OBSERVATION/SUBMISSION TO PLANNING APPLICATION

Case Reference: 324113

Re: Observation to the proposed development of open-cycle gas turbine (OCGT) and generator with ancillary equipment.

Location: Pollnagroagh and Rathmorrissy (Townlands), Athenry, Co. Galway

Purpose		PLANNING			
Title		SITE ACCESS SIGHTLINES			
Original Scale	Design/Drawn	Checked	Authorised		
SHOWN at A1	PS	ND	AJB		
Date	Date	Date	Date		
01.12.25	01.12.25	01.12.25	01.12.25		
Status	Drawing Number	Rev			
A2	PEK3-ATK-ZZ-01-DR-CE-901200	0

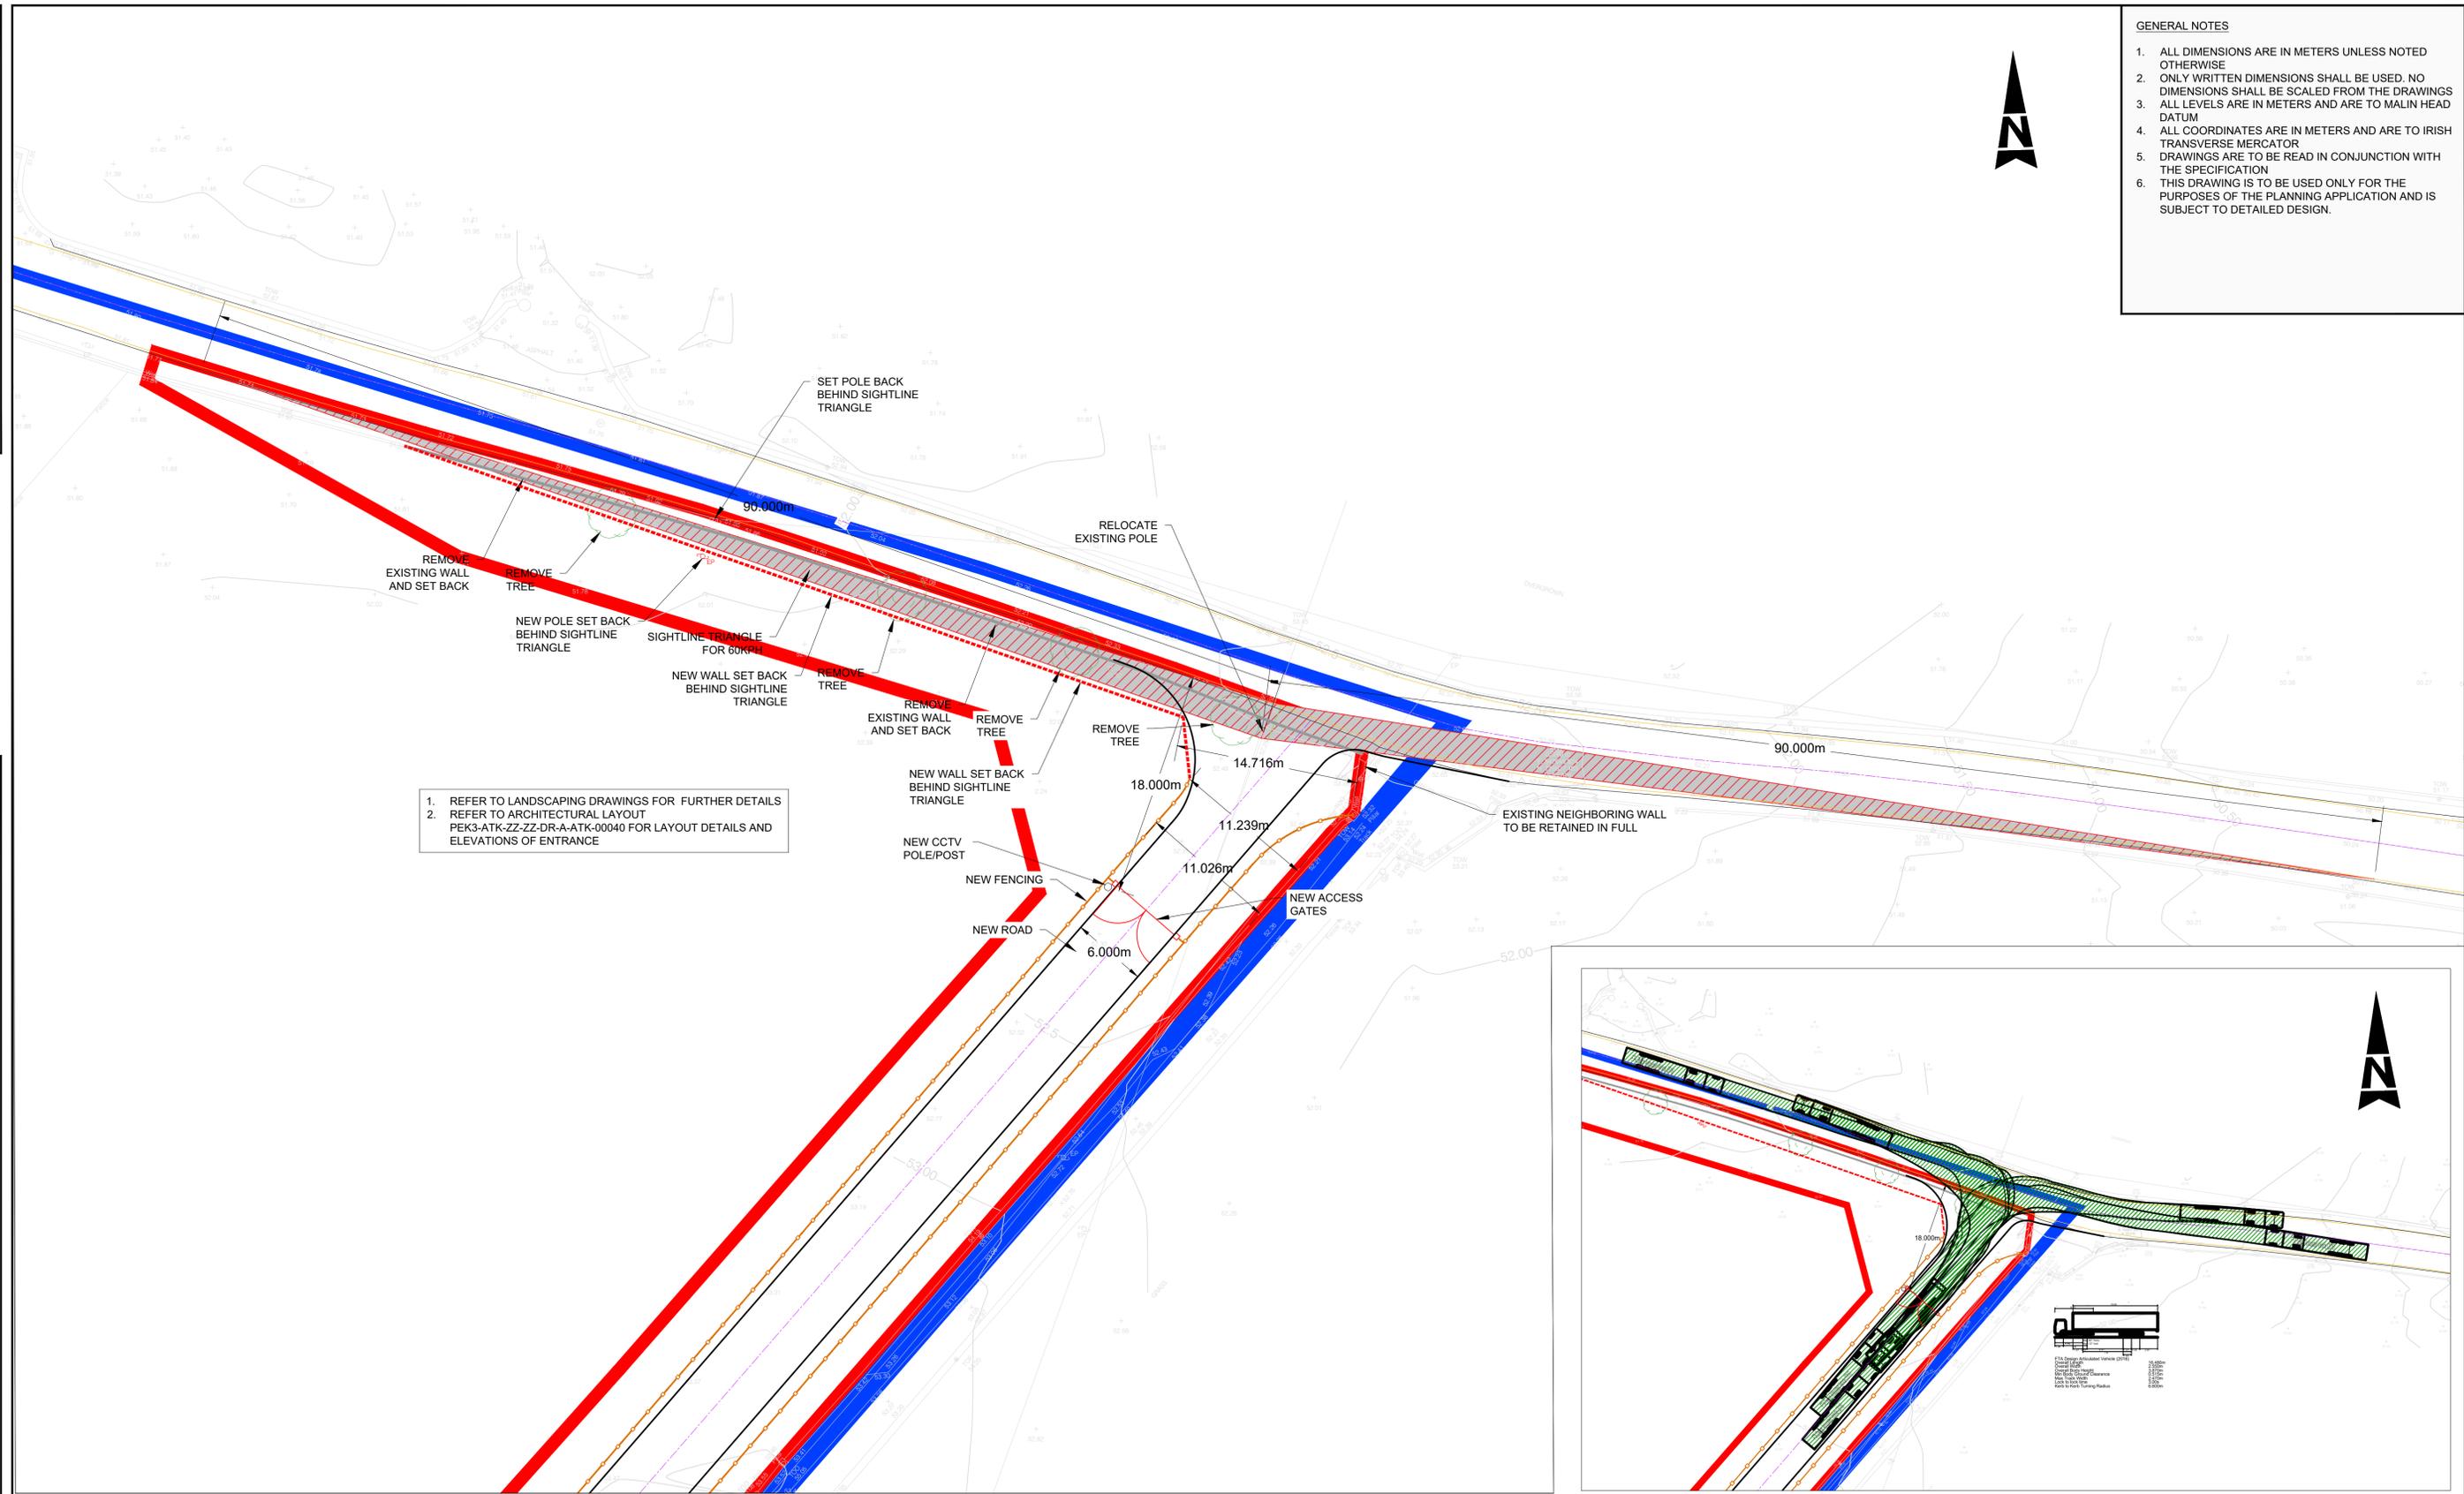
The proposed site entrance is located on an exceptionally dangerous section of the L3103. Establishing an access point at this specific location introduces an unacceptable level of risk due to several compounding hazards:

- Severely Restricted Width: The road is currently too narrow to safely permit two Heavy Goods Vehicles to pass simultaneously.
- Absence of a Hard Shoulder: There is no safe refuge or margin for error for manoeuvring vehicles.
- Critically Poor Visibility: The immediate area is affected by blind dips and blind corners, severely compromising driver sightlines.

These immediate dangers constitute a severe threat to public safety and require urgent and mandatory remediation.
